From: Joseph Clayton <joe.claytonarchitecture@hotmail.com>
Sent: 09 April 2019 10:59
To: _planningadvice; Gedney, David
Subject: Re: H09-0185-19 - Renovation of the Chequers, etc, The Chequers Hotel, 15 High St, Holbeach
Attachments: 117-03 Proposed Floor Plans REVB.pdf; 117-04 Proposed Elevations REVB.pdf; Amendment Form.pdf

Subject: H09-0185-19 - Renovation of the Chequers, etc, The Chequers Hotel, 15 High St, Holbeach

The drawings have had to be amended slightly as the client has been obtaining quotes for various portions of the works and one element has come back far too expensive and as such has had to be omitted.

ELEVATION 03 @ 1:200

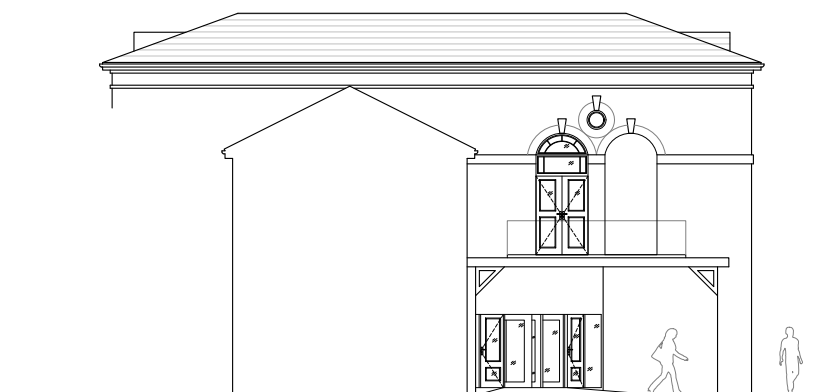
The large arched window on elevation 03 has had 3 quotes back in the region of £15,000 + VAT which makes that element non viable and as such it will have to remain blocked as is for the this application. Our documents suggest that this window has actually been blocked for 80/90 years and I presume this cost has something to do with it.

DWG. NO.:
117-03
REVB

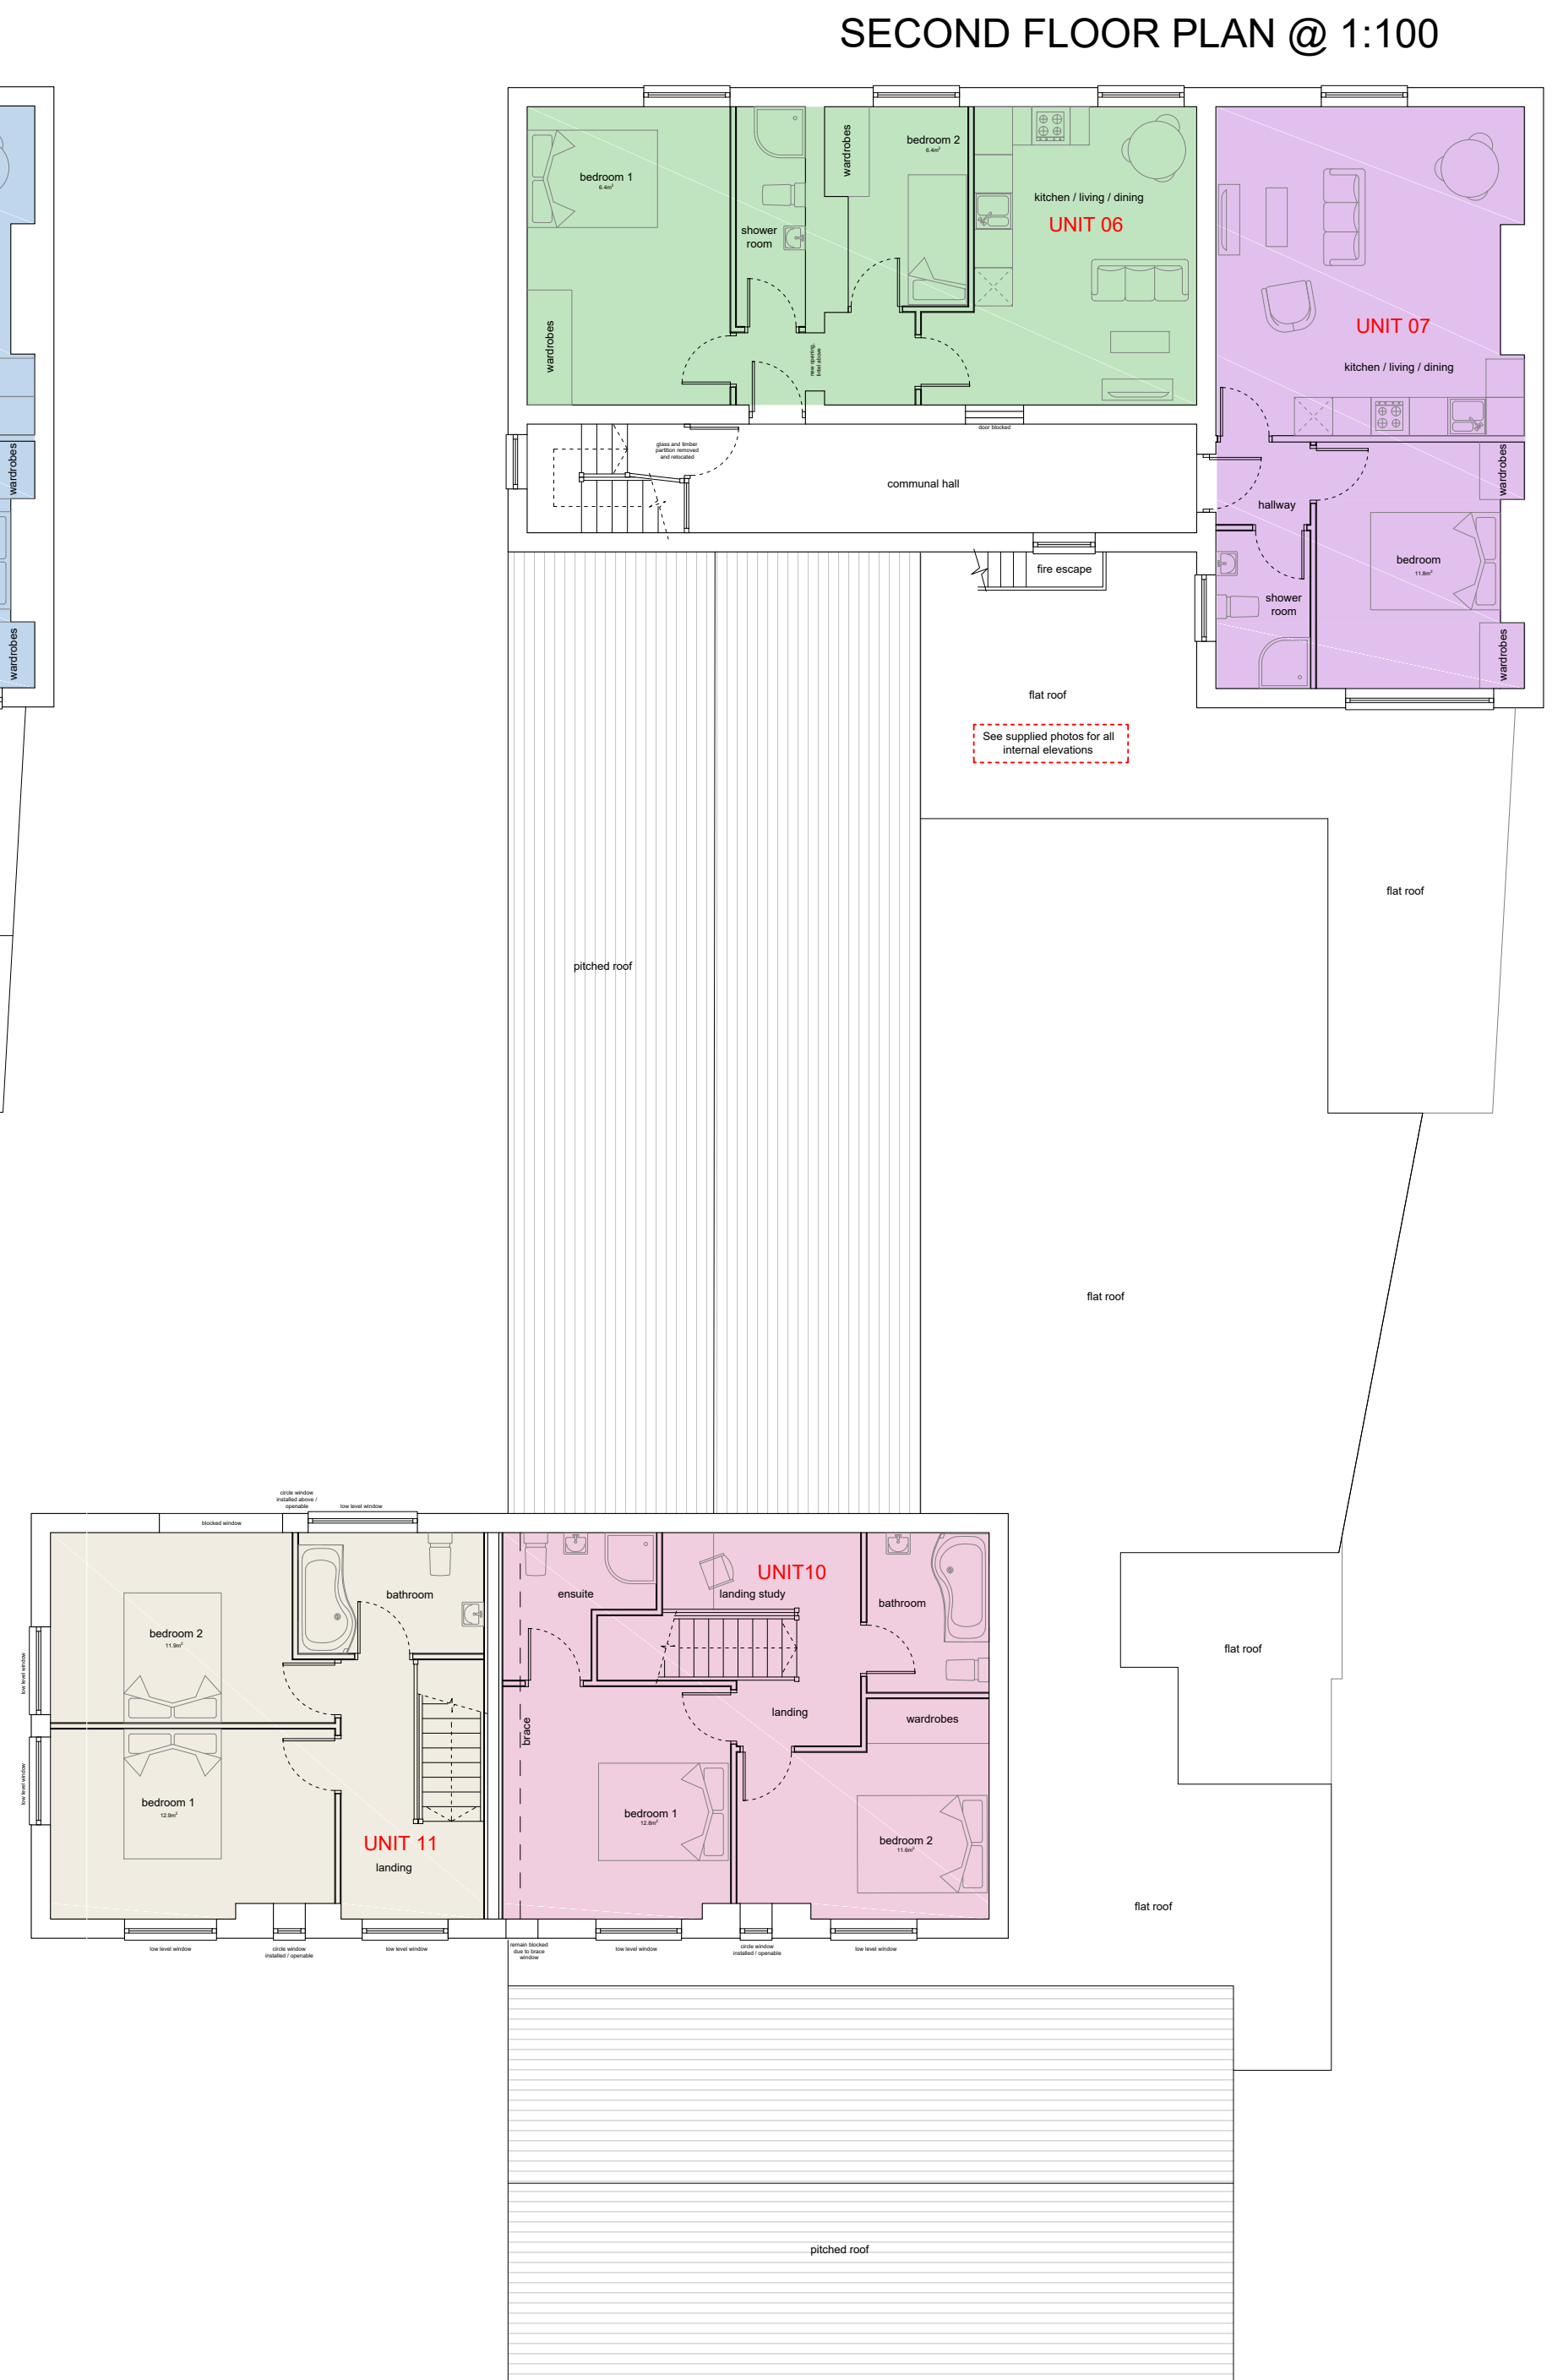
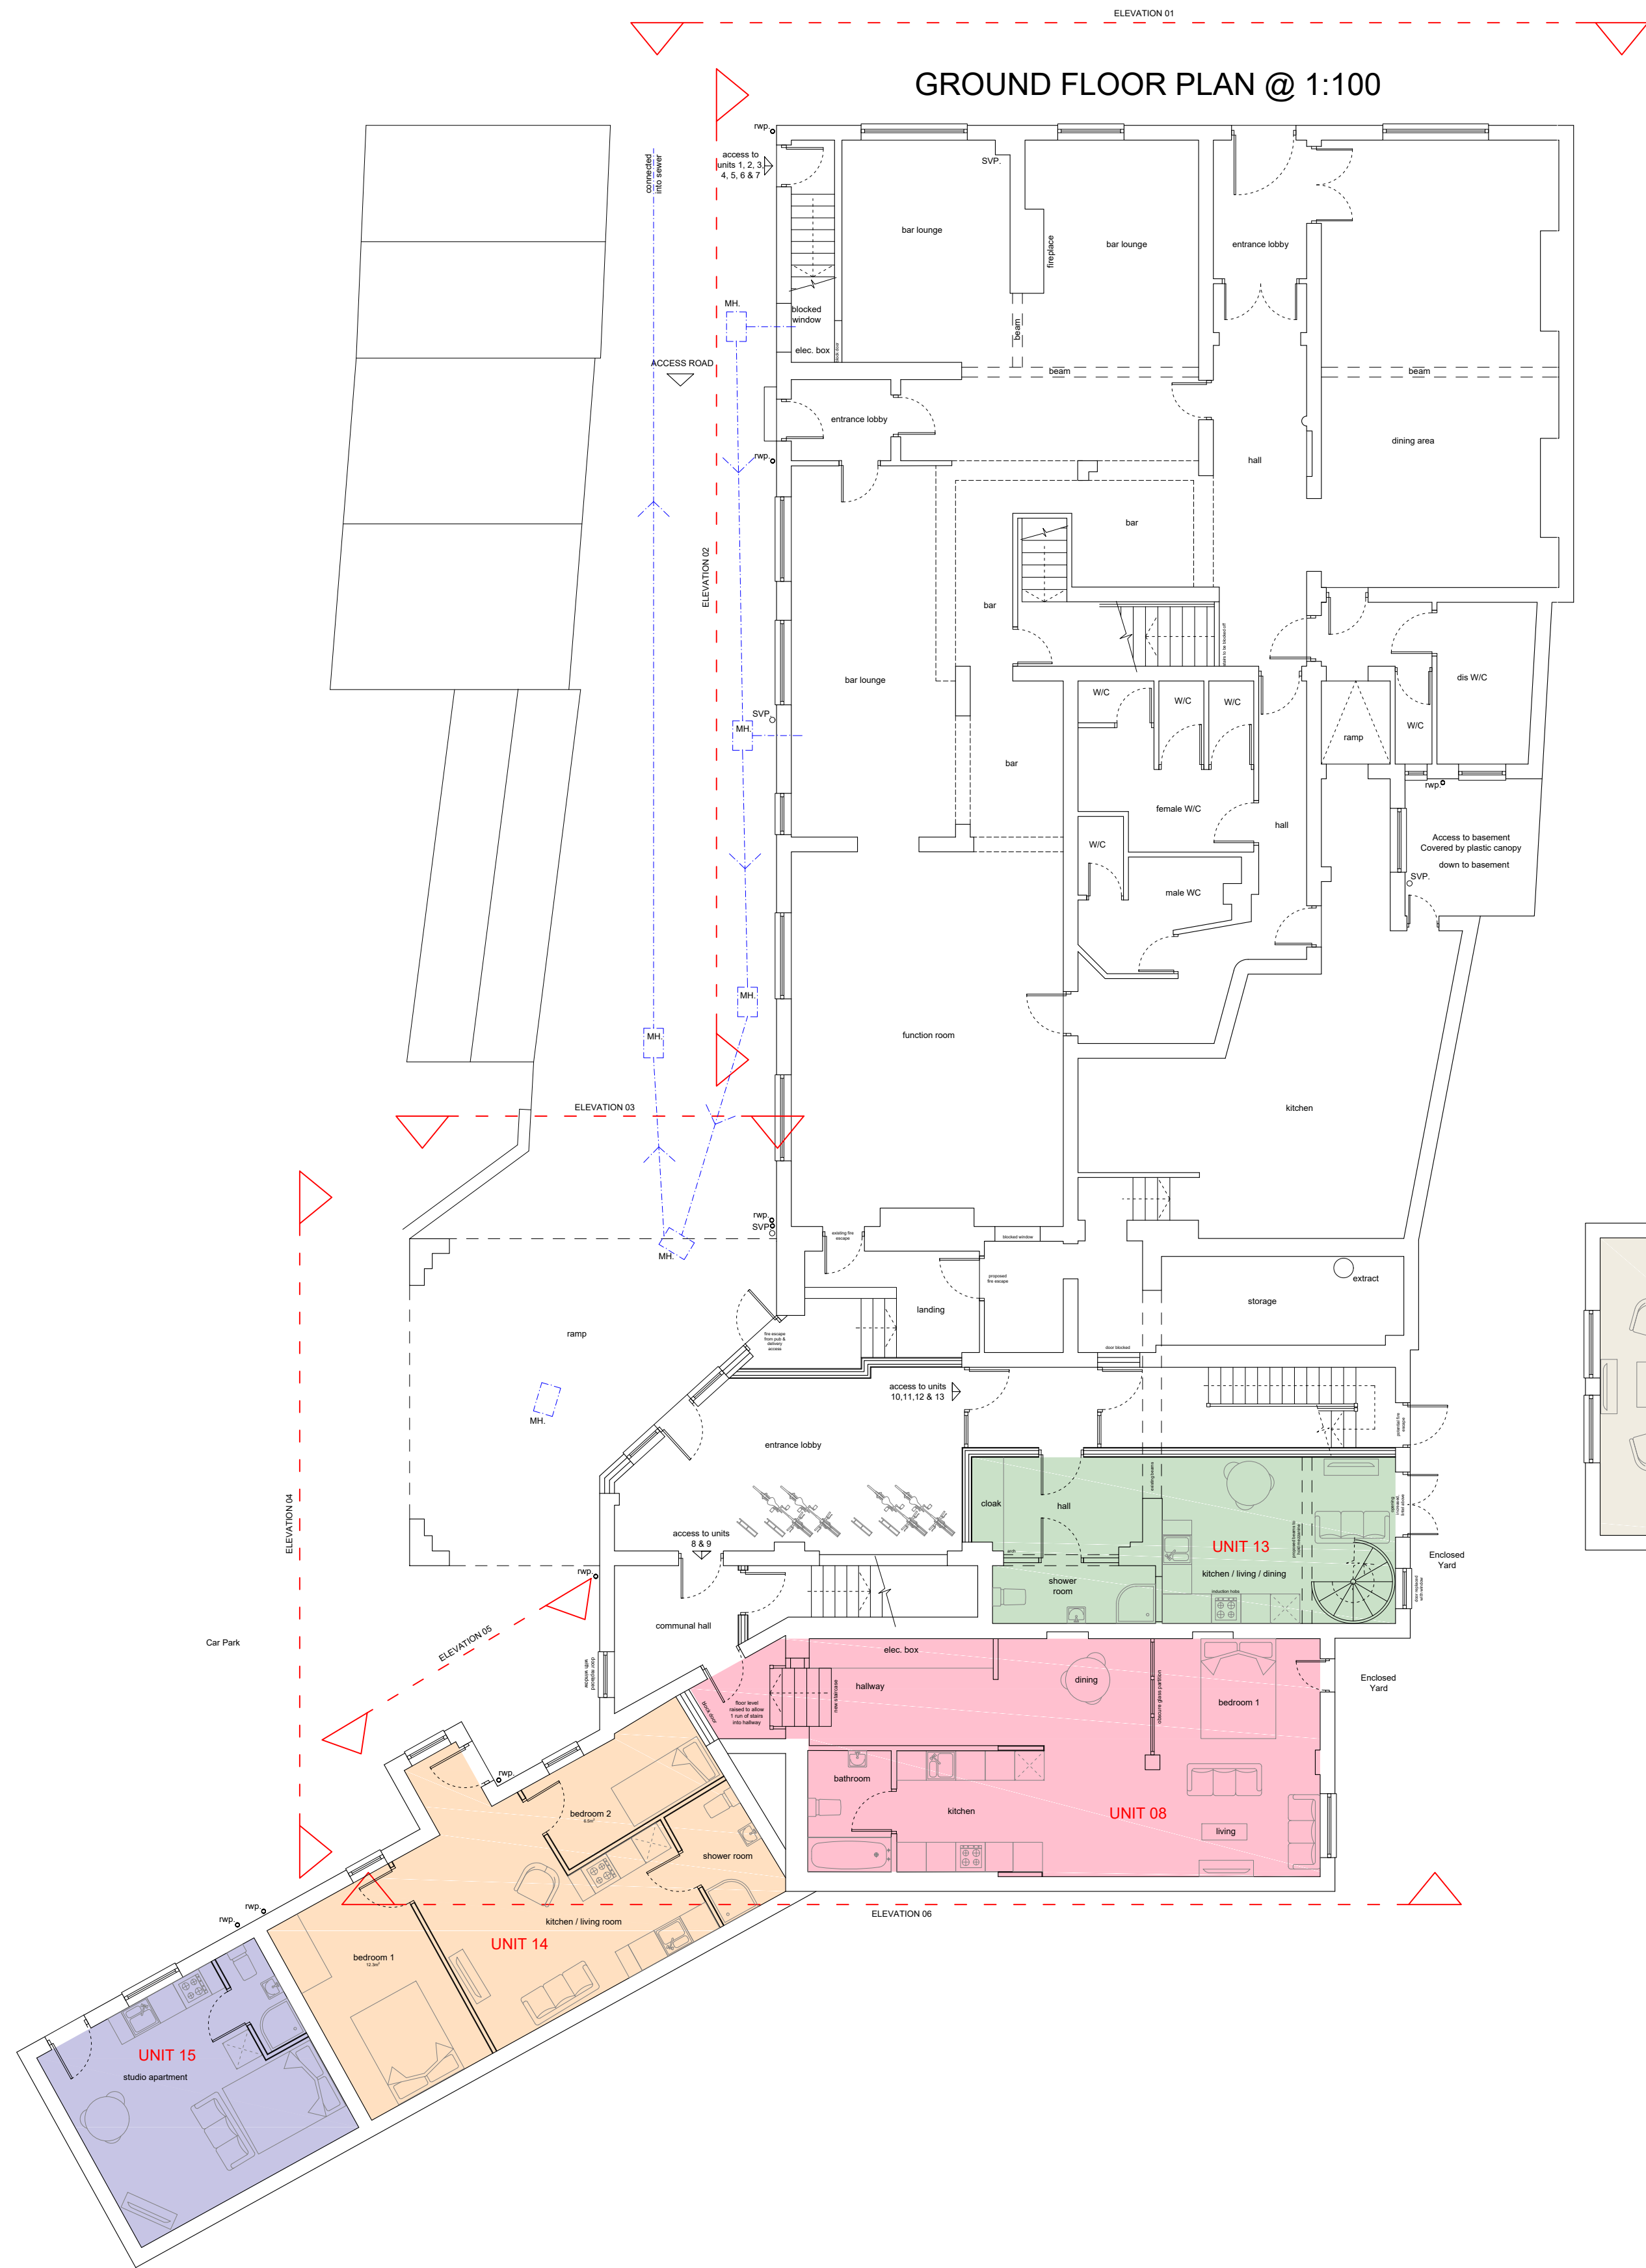
Also on the amended drawings is a slightly revised floor plan. We have reviewed the units and where possible made them more appropriate from a fire regulations point of view by creating enclosed escape routes where possible.
